Our Ref: FP/298/17/HH
Your Ref:

Town & Country Planning Act 1990 (as amended)
Town & country Planning (Development Management Procedure) (England) Order 2015
Application for Planning Permission for Works or Extension to a Dwelling

Development Single storey rear & front flat roof extensions.
Location 17 Somerton Green Felpham

Project	Proposed details November 2017
---------	-----------------------------------

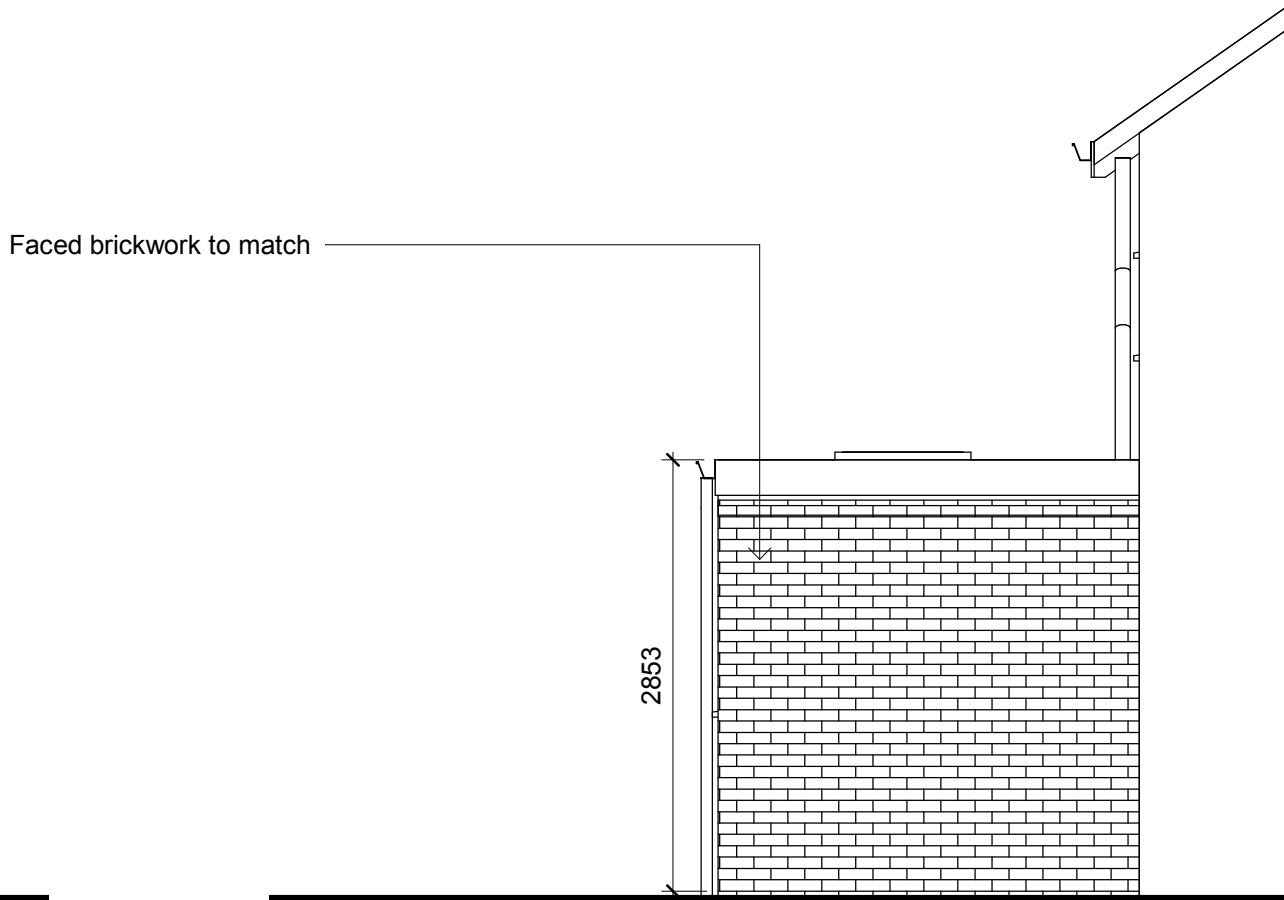
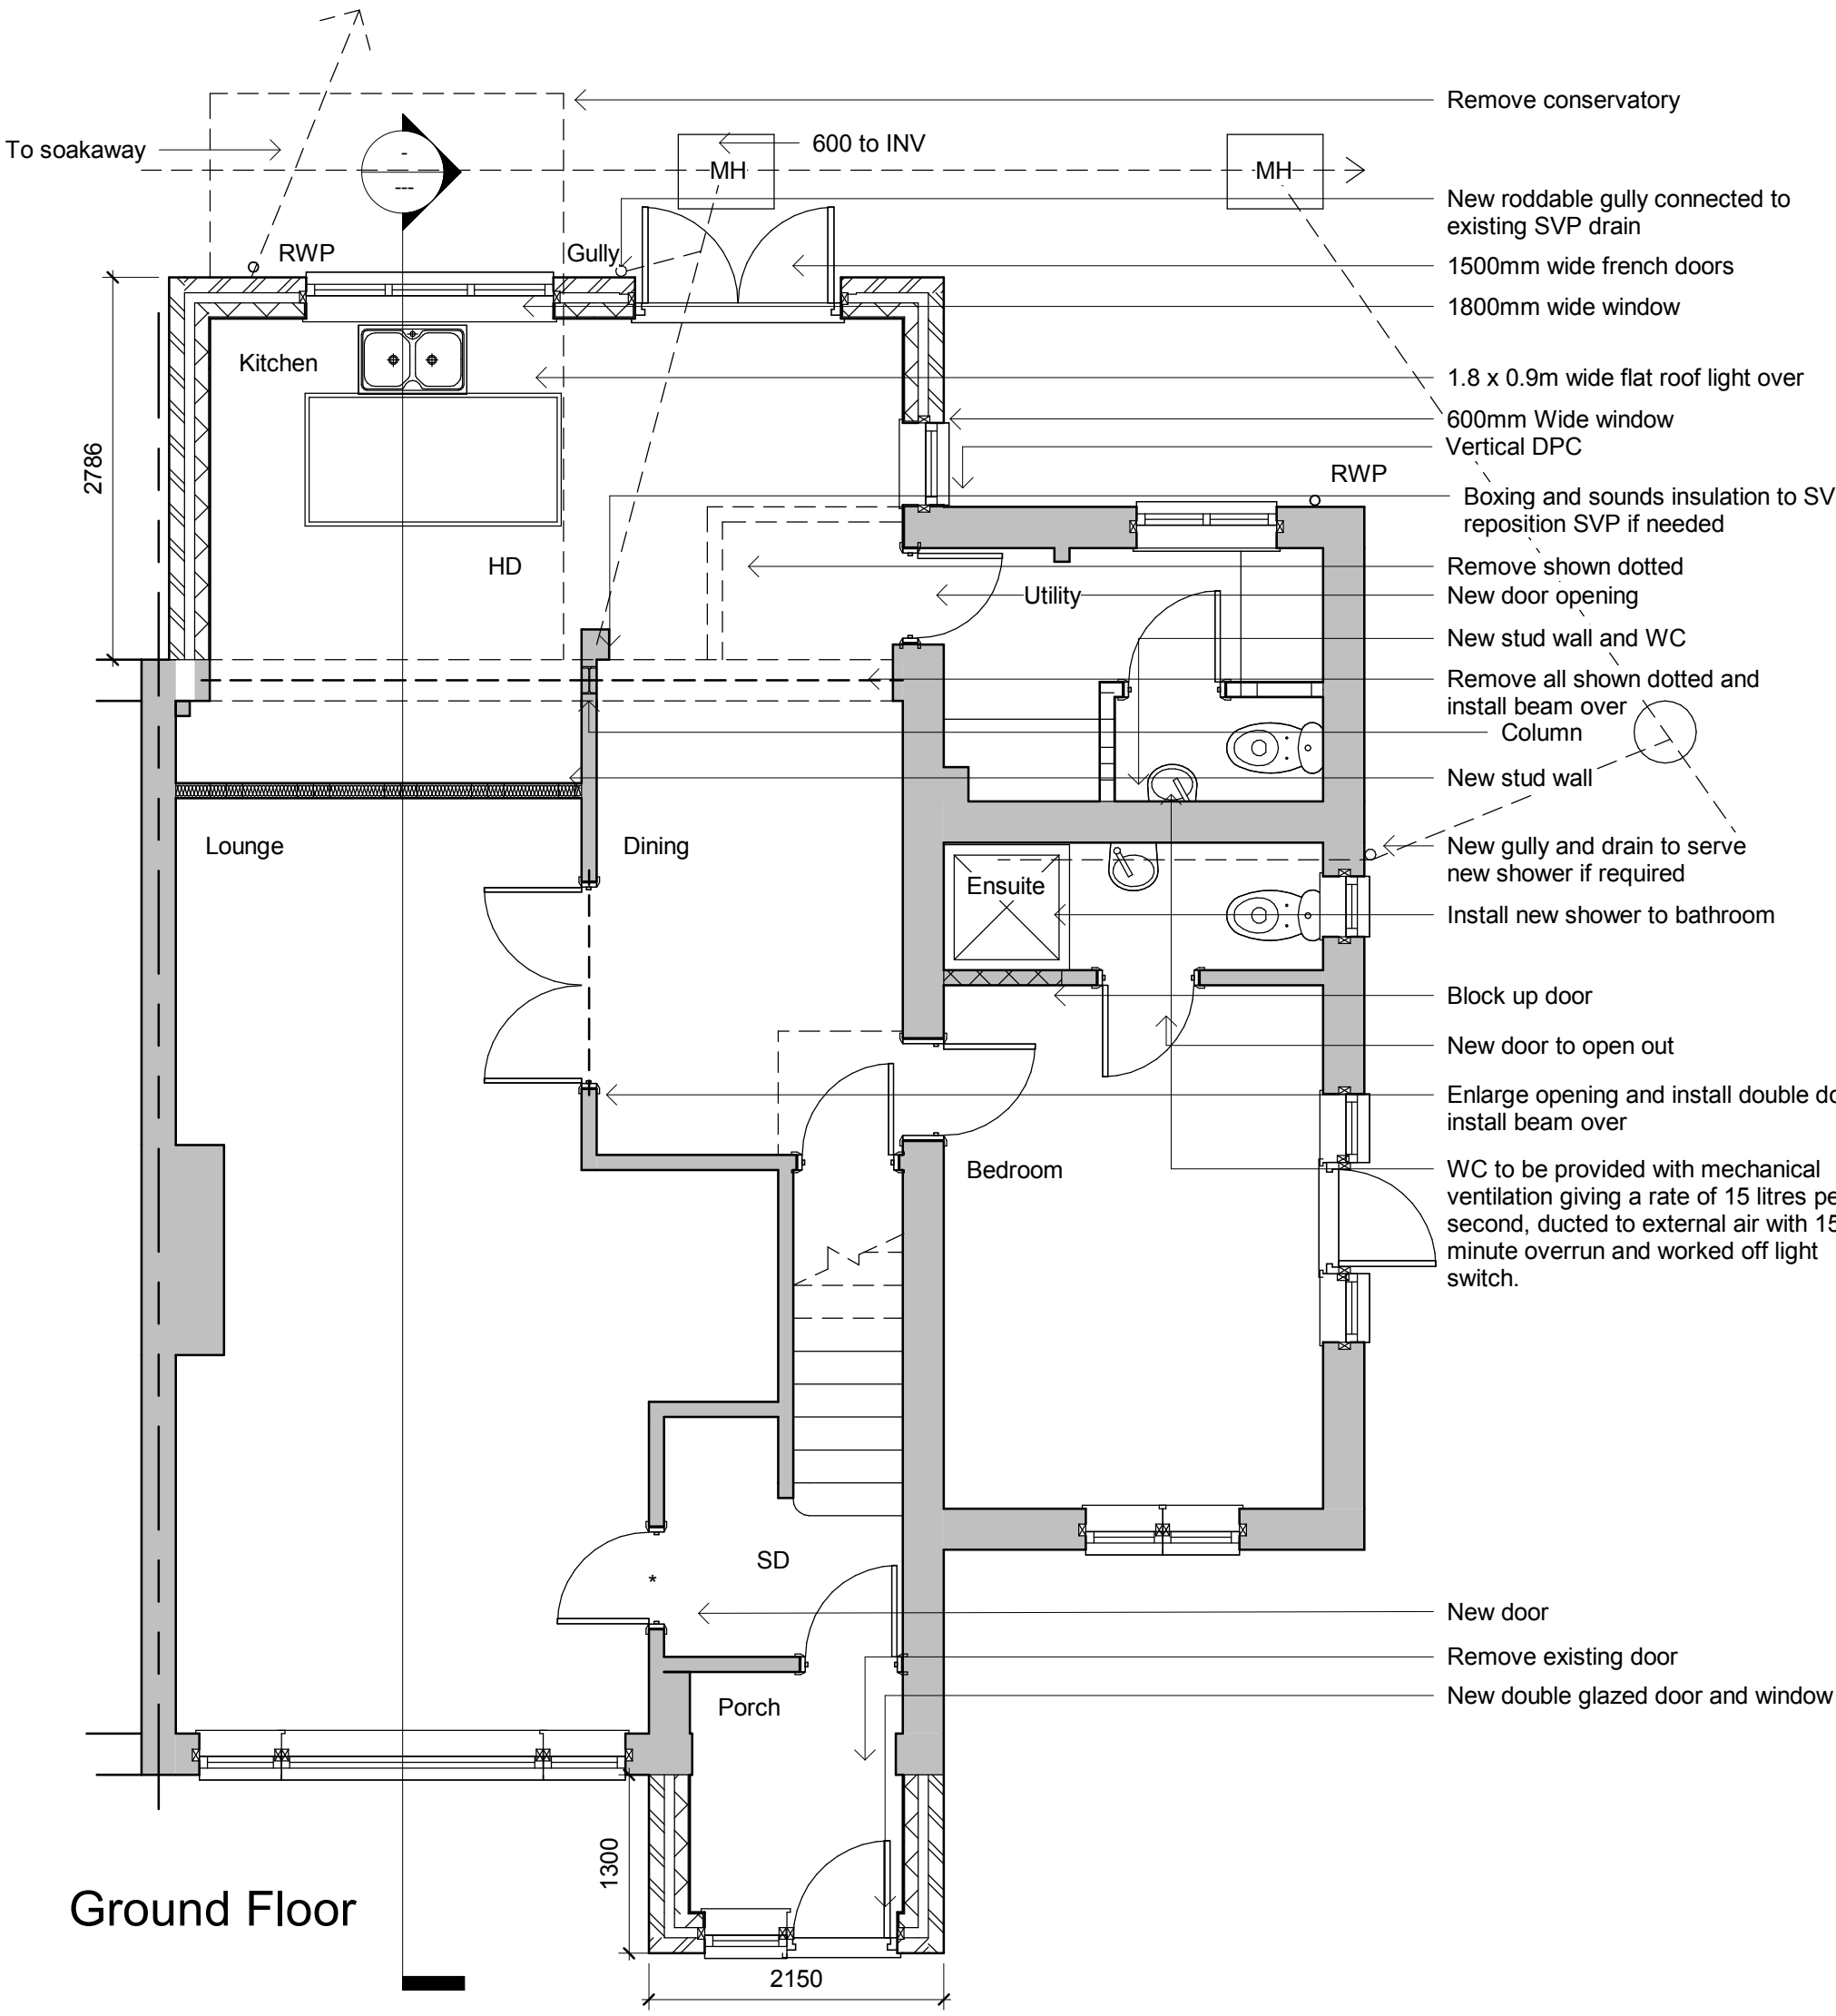
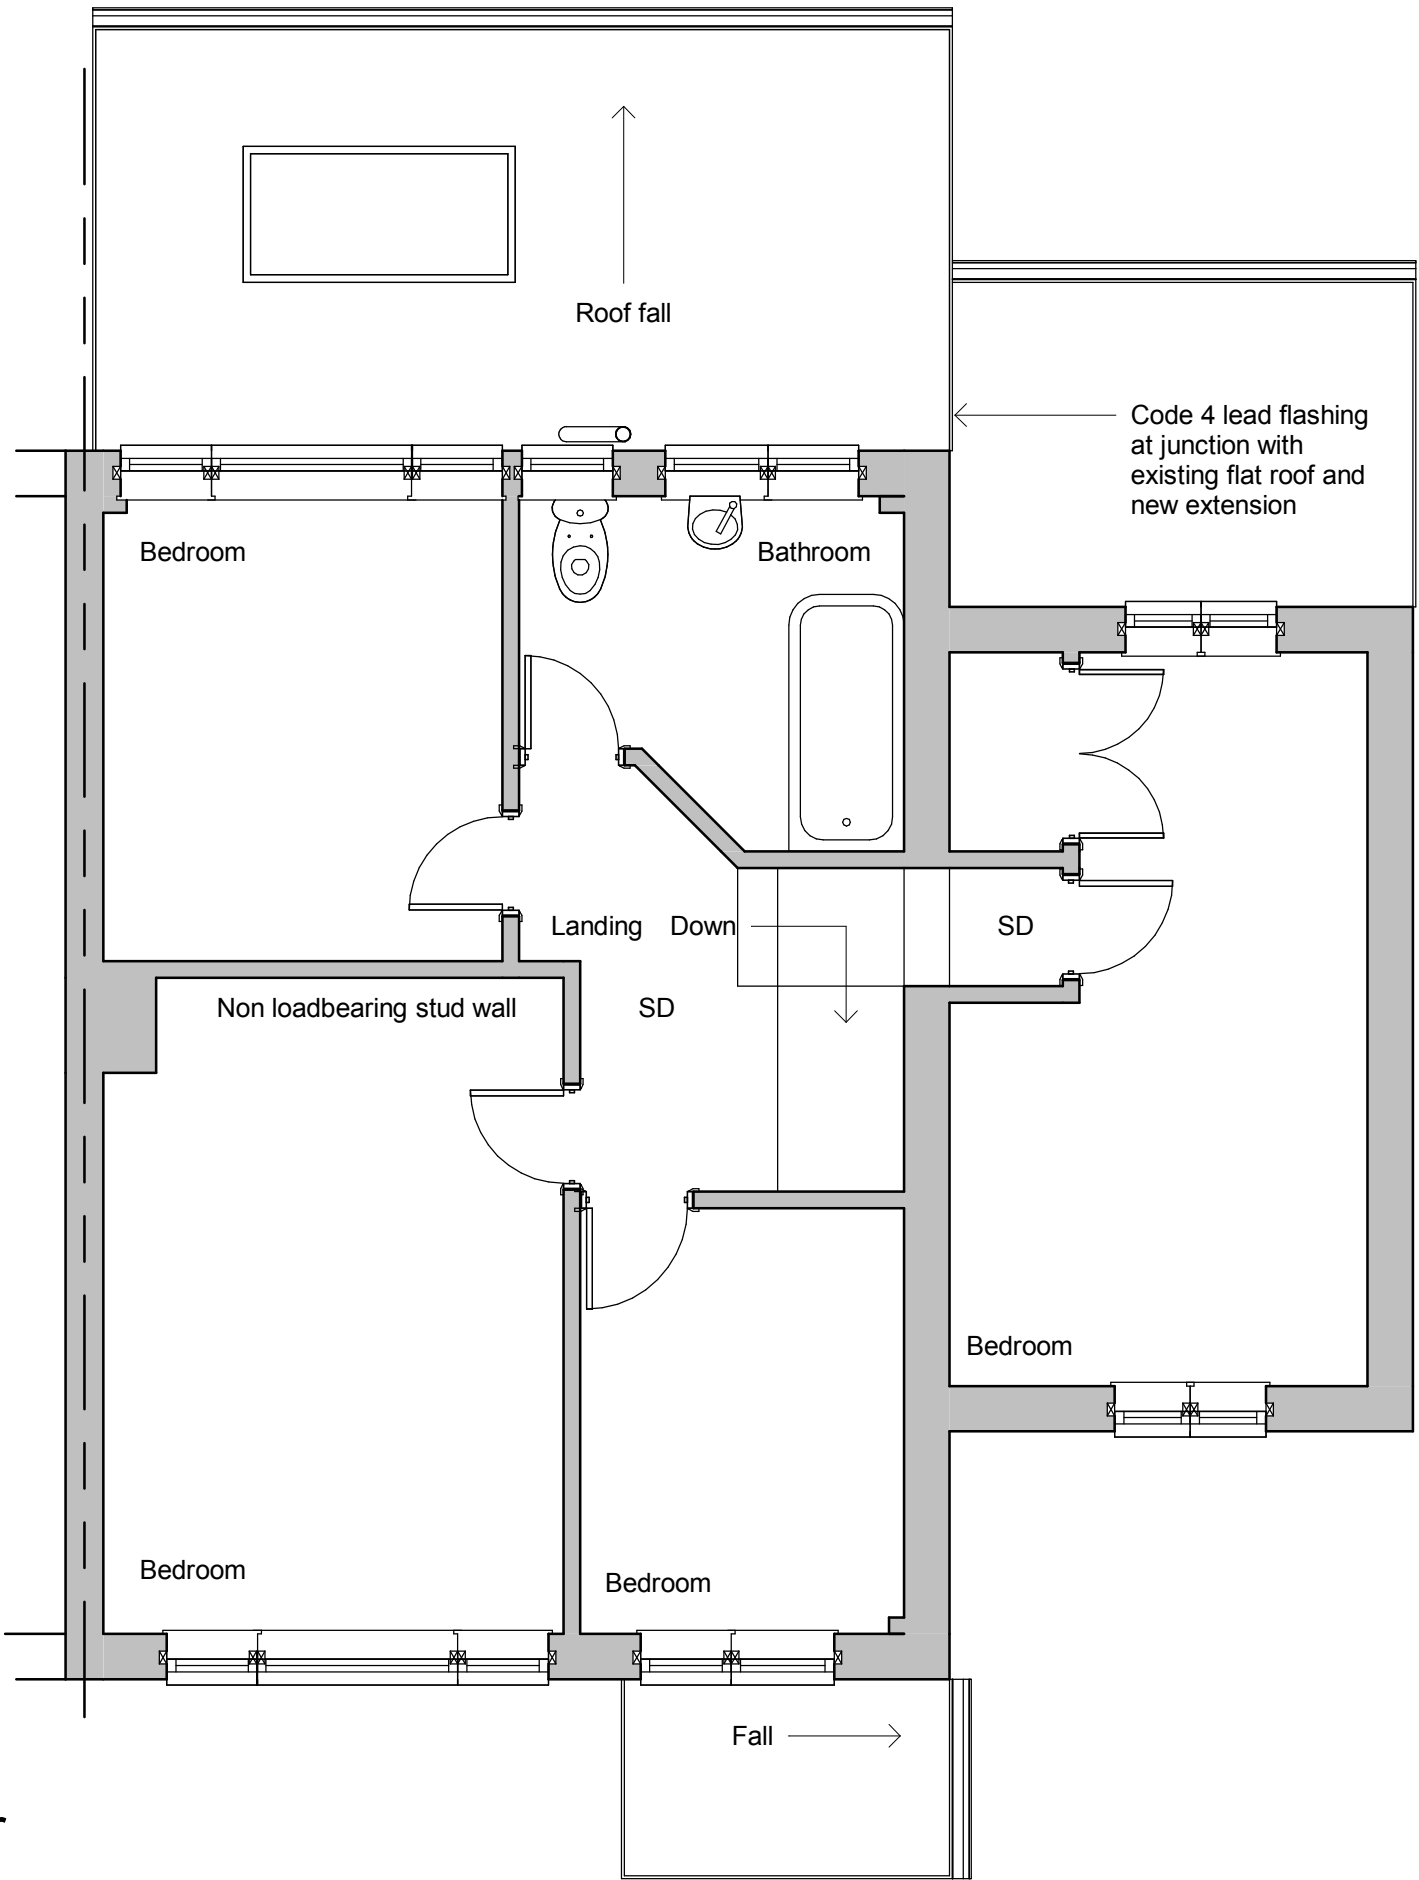
The proposed side elevation and floor plans do not scale correctly. Please amend accordingly.
